Application Reference: 2026/0003

Site Address: Sledbrook House, Sheffield Road, Crow Edge, Barnsley, S36 4HF

This application seeks full planning permission for the installation of a dropped kerb, vehicle crossover, new driveway and works to boundary wall.

Drawing : Proposed Site Layout
Drawing No : SH.03
Site Address : Sledbrook House, Crow Edge, Sheffield S36 4HF

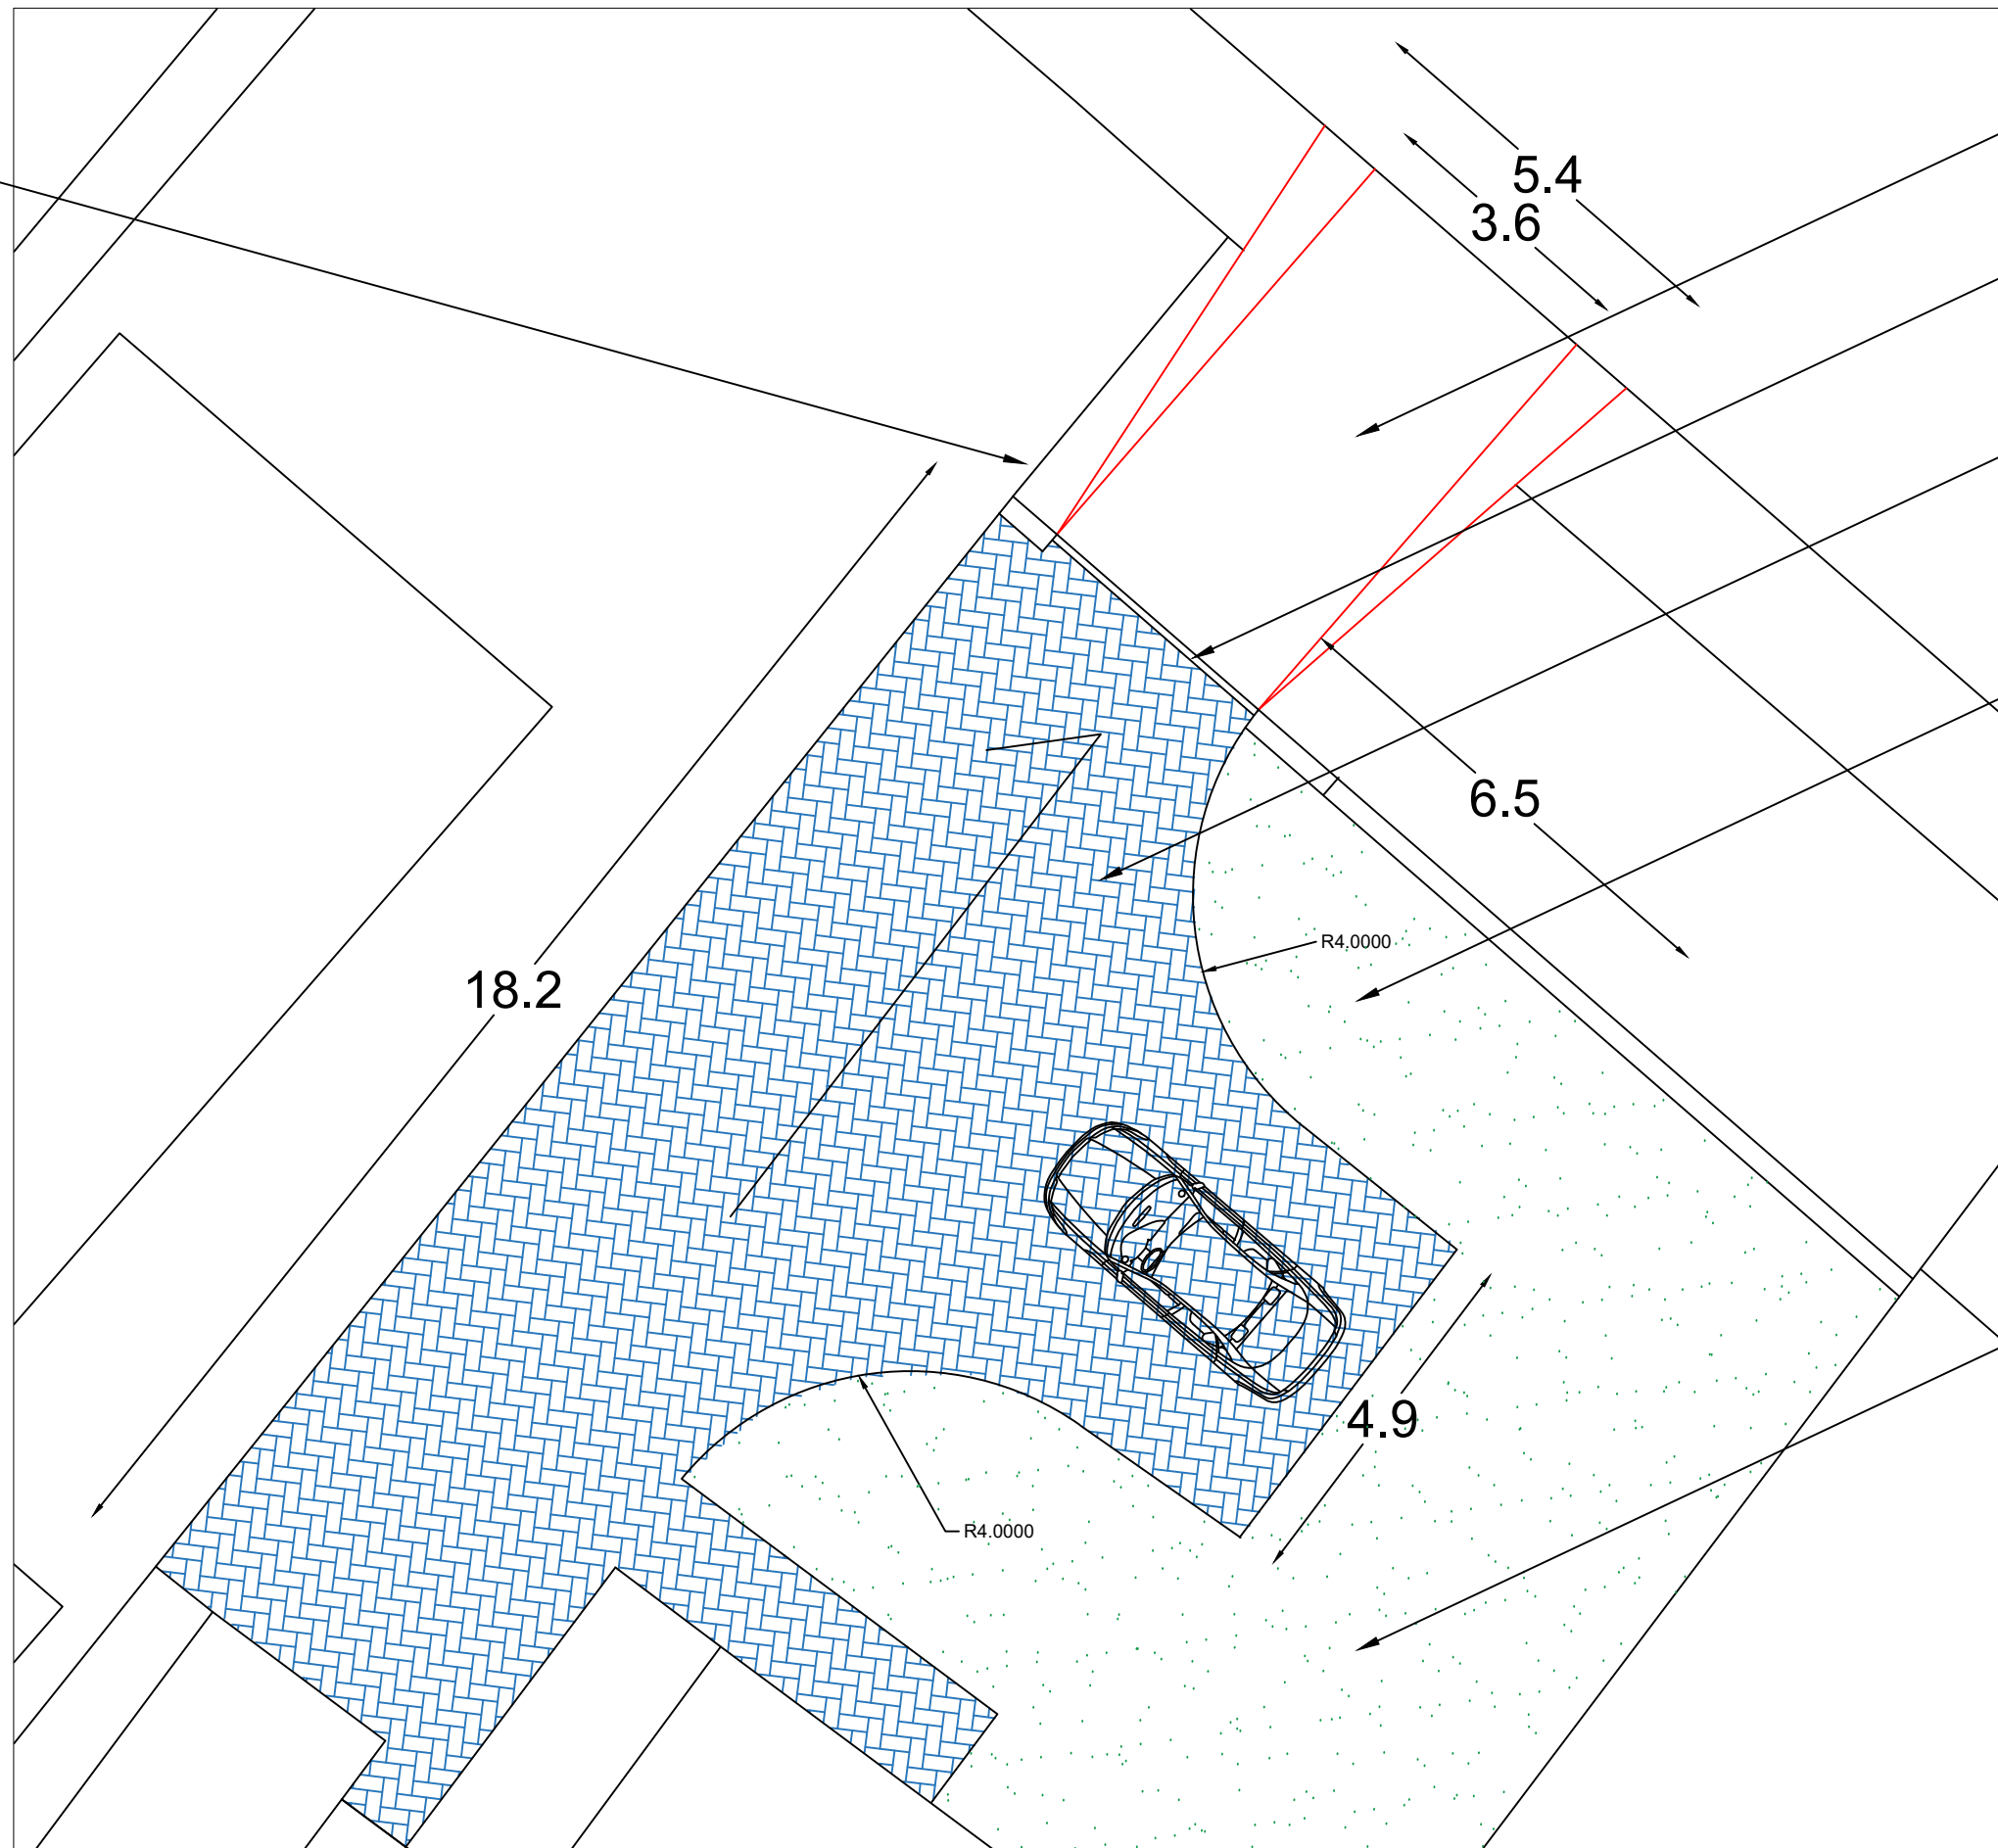
This property is at the end of a row of dwellings to the west of Sheffield Road, most of which have vehicular access on to the classified road. The site has planning permission refused for the formation of an access in 2022. This was refused because the application didn't allow for cars to turn around within the site. This application allows for a turning circle within the site using block paving. The front boundary wall will be altered to allow for access.

The neighbour has some concerns with regards to the impact to the grass verge at the front of the property. As only a small area of grass verge will be impacted as part of this proposal, this small loss of verge is not expected to negatively impact the visual amenity of the area.

The site is located along Sheffield Road, a classified route (A616) that runs through Crow Edge. Given that Sheffield Road is classified, there is a requirement for vehicles to be able to turn within the site curtilage so that they can enter and exit in a forward gear in the interests of highway safety. Classified roads by their very nature are busier roads and it is considered that vehicles reversing to/from the driveway would have a detrimental impact on highway safety for oncoming vehicles on Sheffield Road. The previous application 2022/0501 was refused due to the lack of turning area within the site. This proposal overcomes the reason for refusal.

The proposal will see the installation of a block paved driveway capable of providing a turning area for vehicles to enter and leave the site in a forward gear. Therefore, the proposals are considered acceptable from a highways development control perspective as they are viewed as being in compliance with Local Plan Policy T4 New development and Transport Safety.
